CITY OF ALBUQUERQUE

RE: Valle Vista at the Trails, Unit 2 (File: C09D009)
Grading and Drainage Plan, Engineer's Stamp Date 6-23-2014
Revised Grading Plan, (verbally approved) Engineer's Stamp Date 1-20-15
Engineer's Certification Date: 3-18-16

Based upon the information provided in your submittal received 10-23-15, the above referenced plan cannot be accepted for Release of Financial Guarantee for grading and drainage until the following are addressed:

CITY OF ALBUQUERQUE PUBLIC WORKS DEPARTMENT	
VALLE VISTA UNITS 1, 2 & 3 GRADING AND DRAINAGE PLAN			
Design Review Committee	City Engineer Approval	Last Design Update	Mo./Day/Yr.
City Project No.	Zone Map No.	Sheet	Of
XXXXXX	C-09-Z	1	2

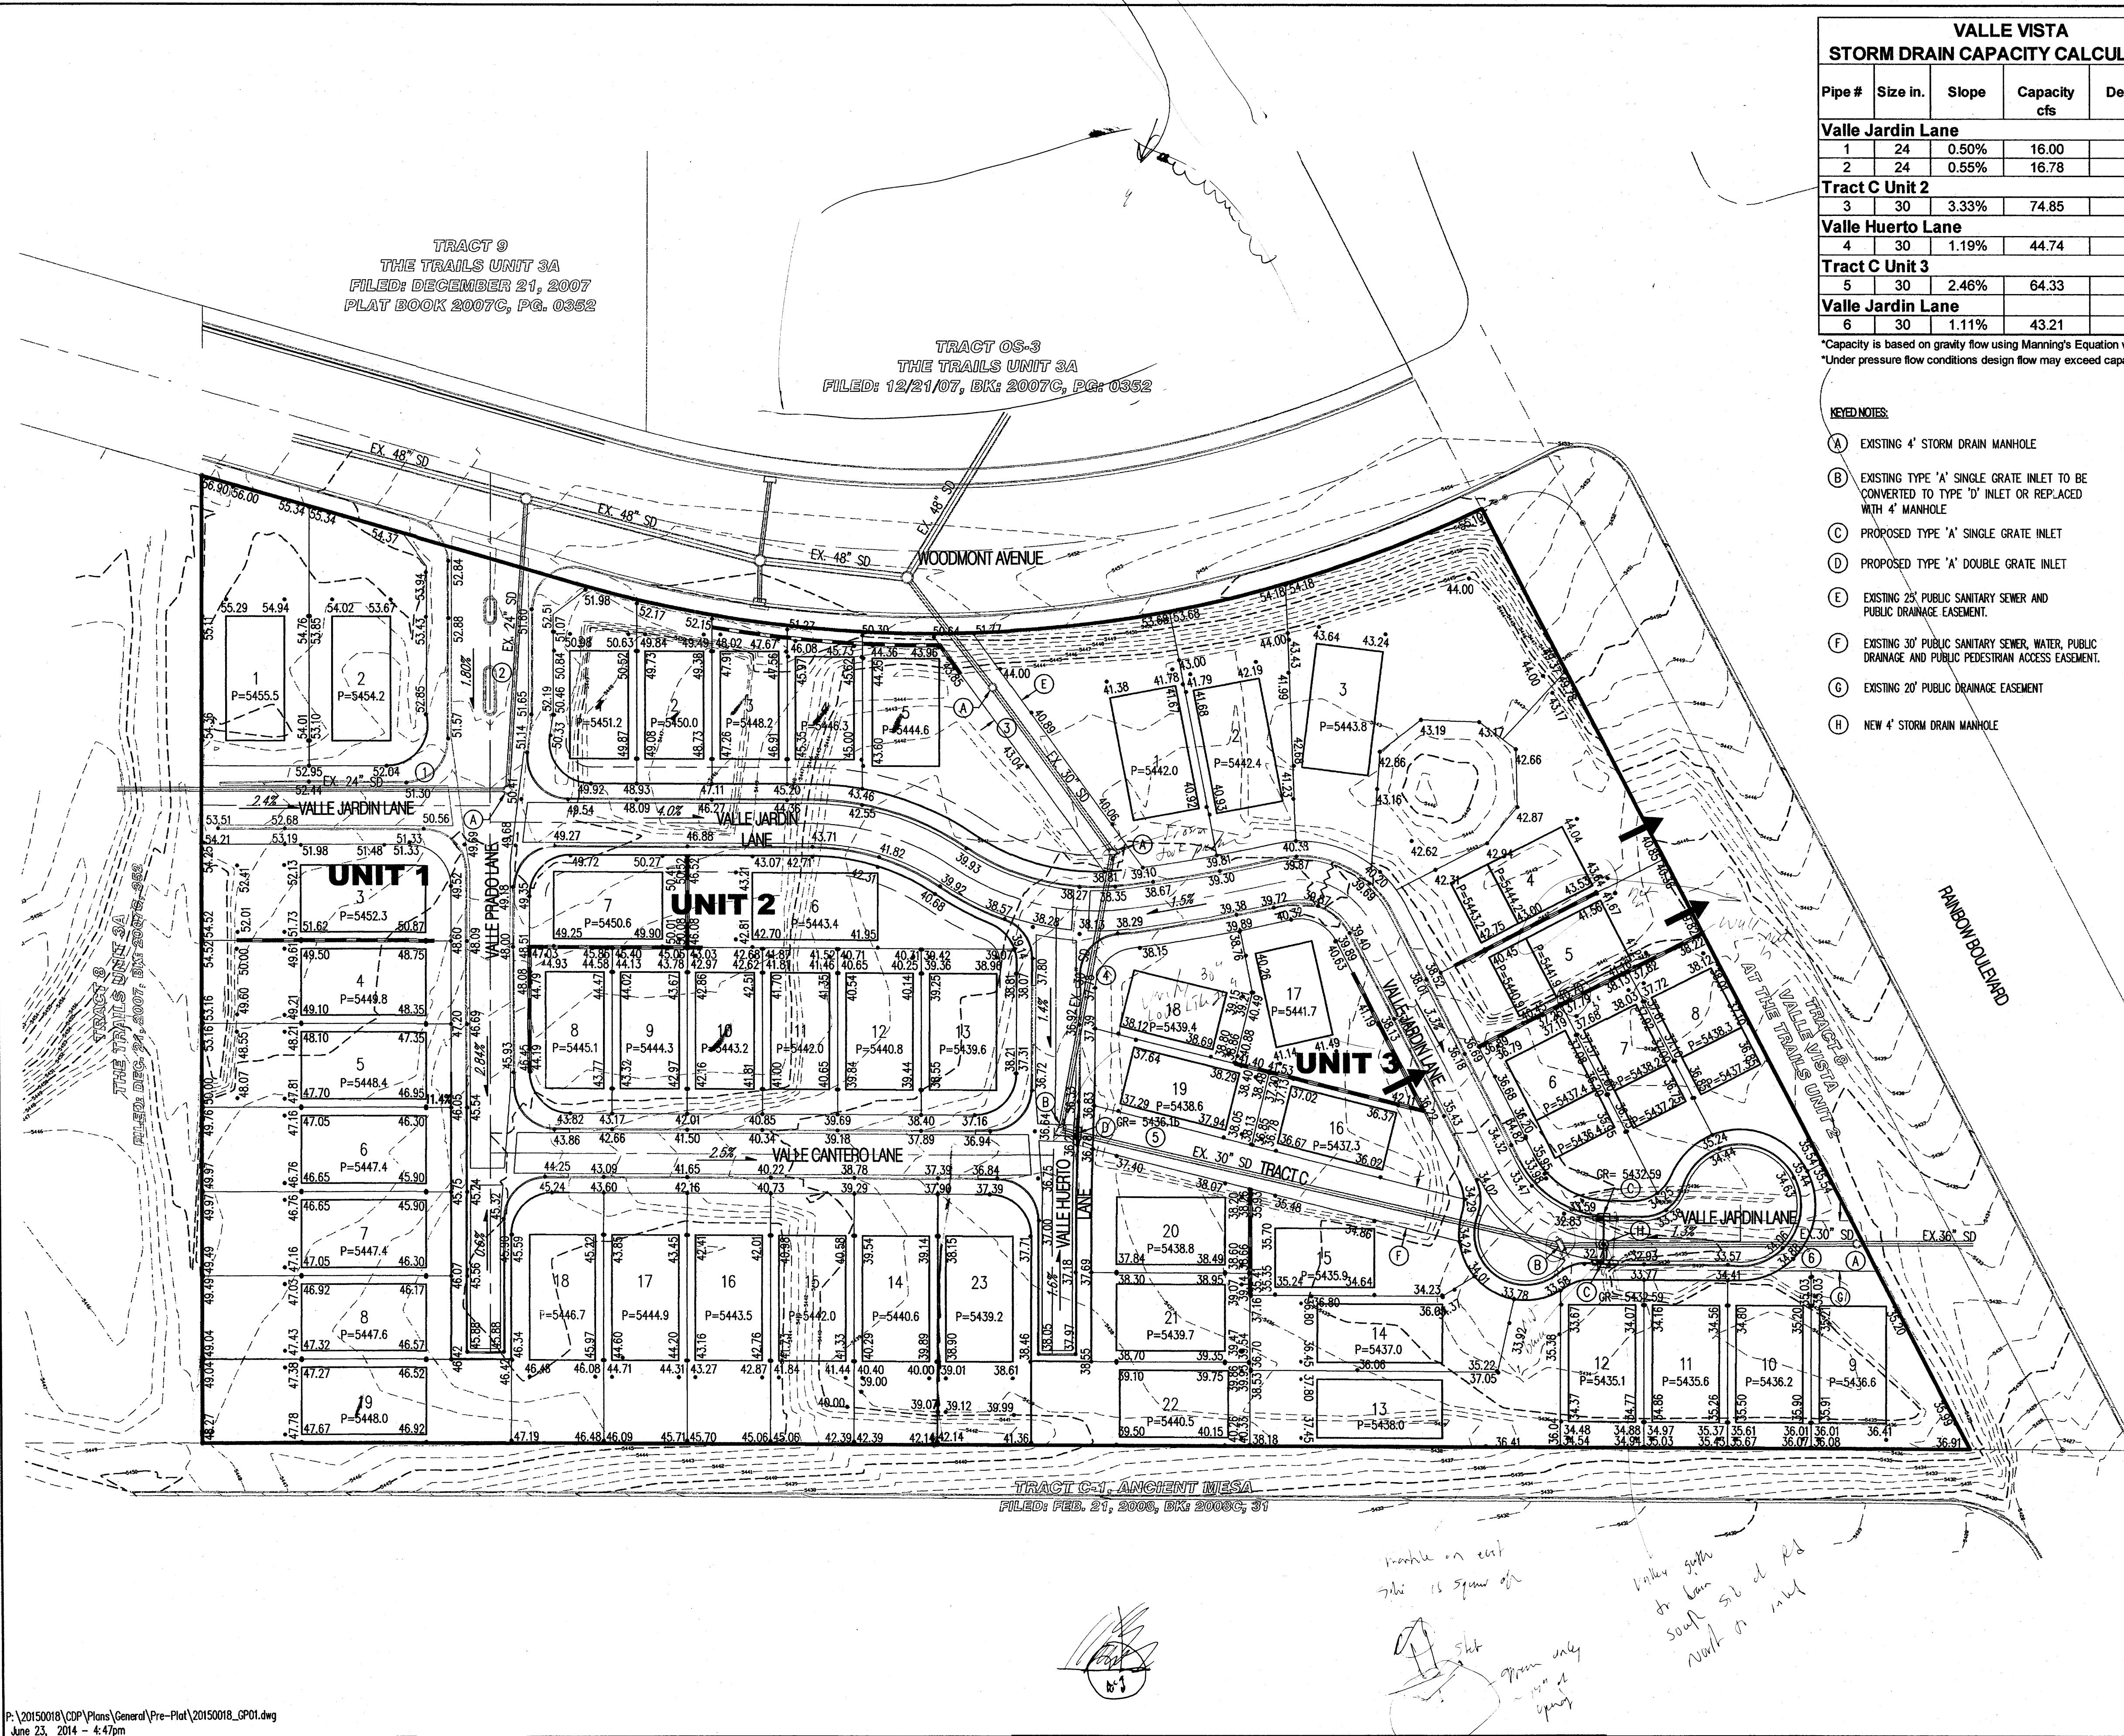
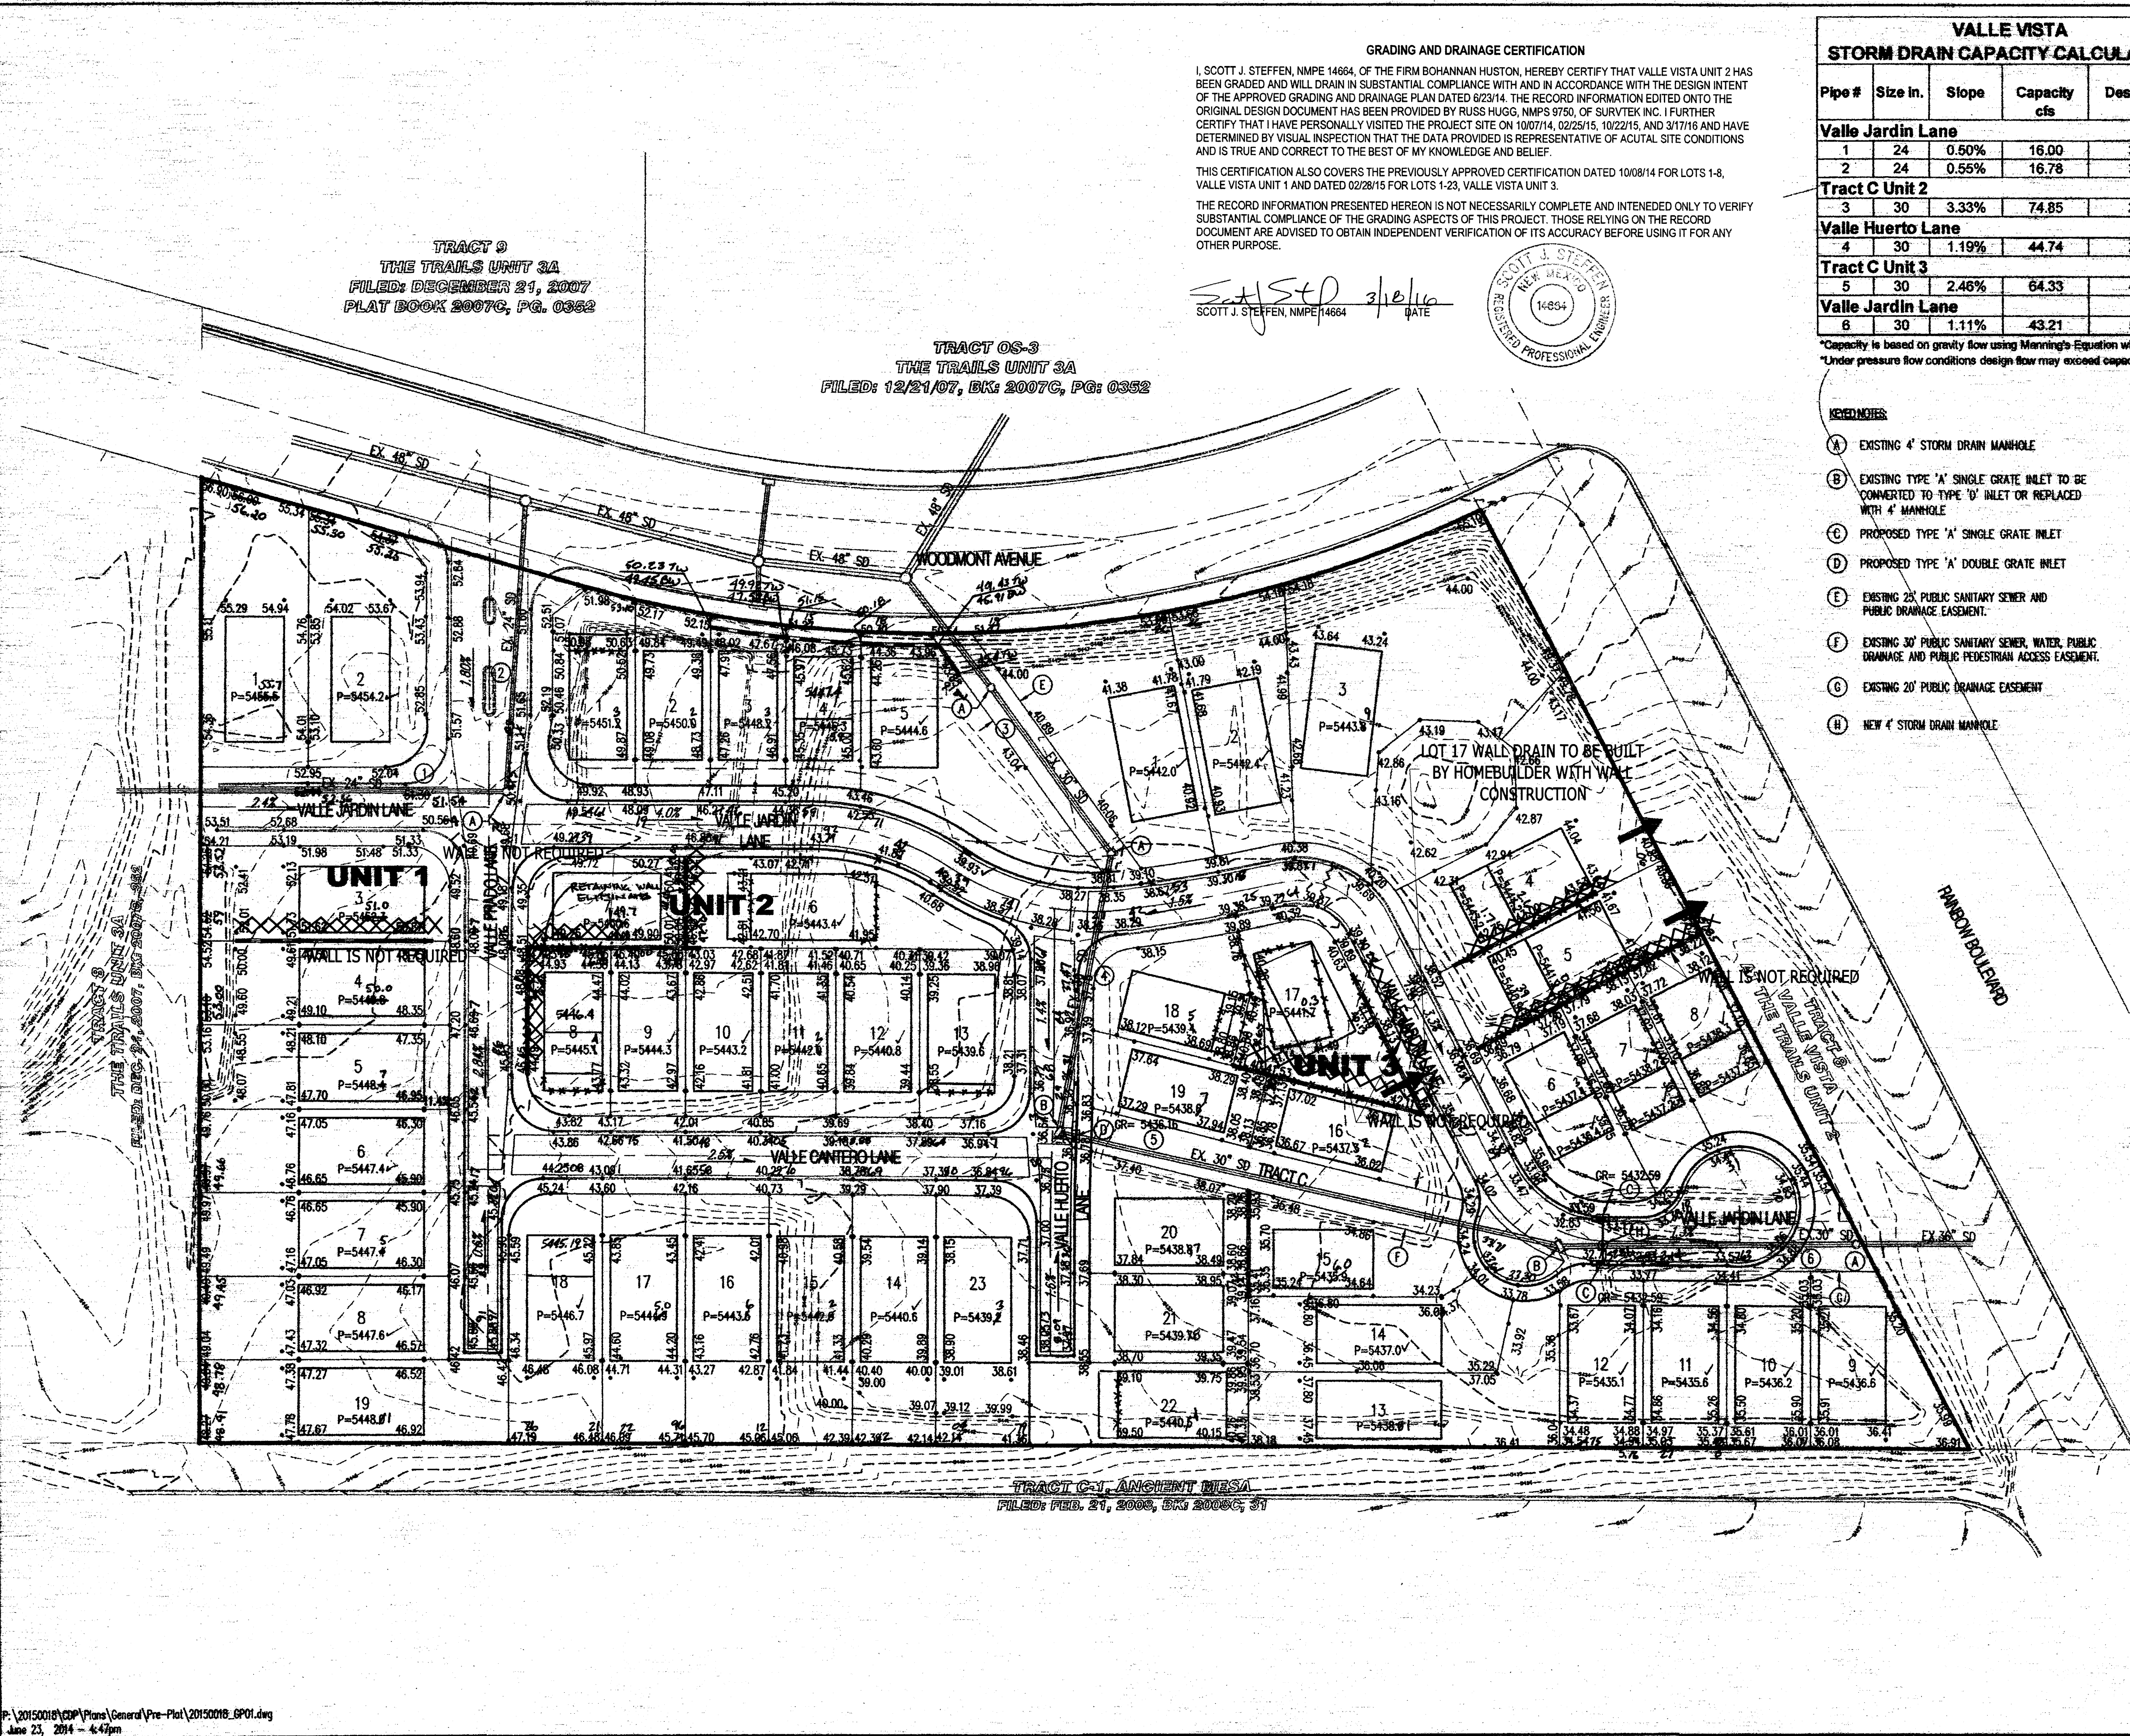
2. The retaining wall at the rear of Lot 5 appears to have collapsed.
3. Manhole in SD Tract east of Lot 5 needs to be adjusted to grade.
4. Lot 3 rear retaining wall is intended to be a garden wall retaining 2' to be built by the homebuilder. However, what mechanism is in place for the City to ensure that such a wall is built? If no such mechanism is in place, this wall should be constructed prior to Release of Financial Guarantee. Furthermore, should the garden wall not be built, the existing wall beyond is susceptible to overturning since the supporting soil is not in place.

5. The split between Lots 7 and 8 is over 2', and needs a retaining wall as per the plan.
6. The split between Lot 6 and 7 is over 4' and needs a retaining wall as per the plan.

2. *The retaining wall at the rear of Lot 5 appears to have collapsed. **As previously discussed, the retaining wall has not collapsed, but actually turns an approximate 45 degree angle and steps down the slope.***

3. *Manhole is SD Tract east of Lot 5 needs to be adjusted to grade. **The manhole has been adjusted.***
4. *Lot 3 rear retaining wall is intended to be a garden wall retaining 2' to be built by the homebuilder. However, what mechanism is in place for the City to ensure that such a wall is built? If no such mechanism is in place, this wall should be constructed prior to Release of Financial Guarantee. Furthermore, should the garden wall not be built, the existing wall beyond is susceptible to overturning since the supporting soil is not in place. **The 2' garden wall has been built, see as-built elevations on the grading plan.***

5. *The split between Lots 7 and 8 is over 2', and needs a retaining wall per the plan. **See the revised grading plan dated 1/20/15. The split is 2' or less, which will be built as part of the garden wall by the homebuilder.***
6. *The split between Lots 6 and 7 is over 4', and needs a retaining wall per the plan. **See the revised grading plan dated 1/20/15. The property line split is 2', with a slope in the rear yard. The 2' split will be incorporated in the garden wall, which will be built by the homebuilder.***
7. *Valley gutter at intersection of Valle Prado Lane and Valle Cantero Lane is chipped along an edge, and the asphalt is not flush. **The valley gutter is part of the Unit 1 infrastructure which has been accepted by the City. In addition, the streets in Valle Vista are private.***
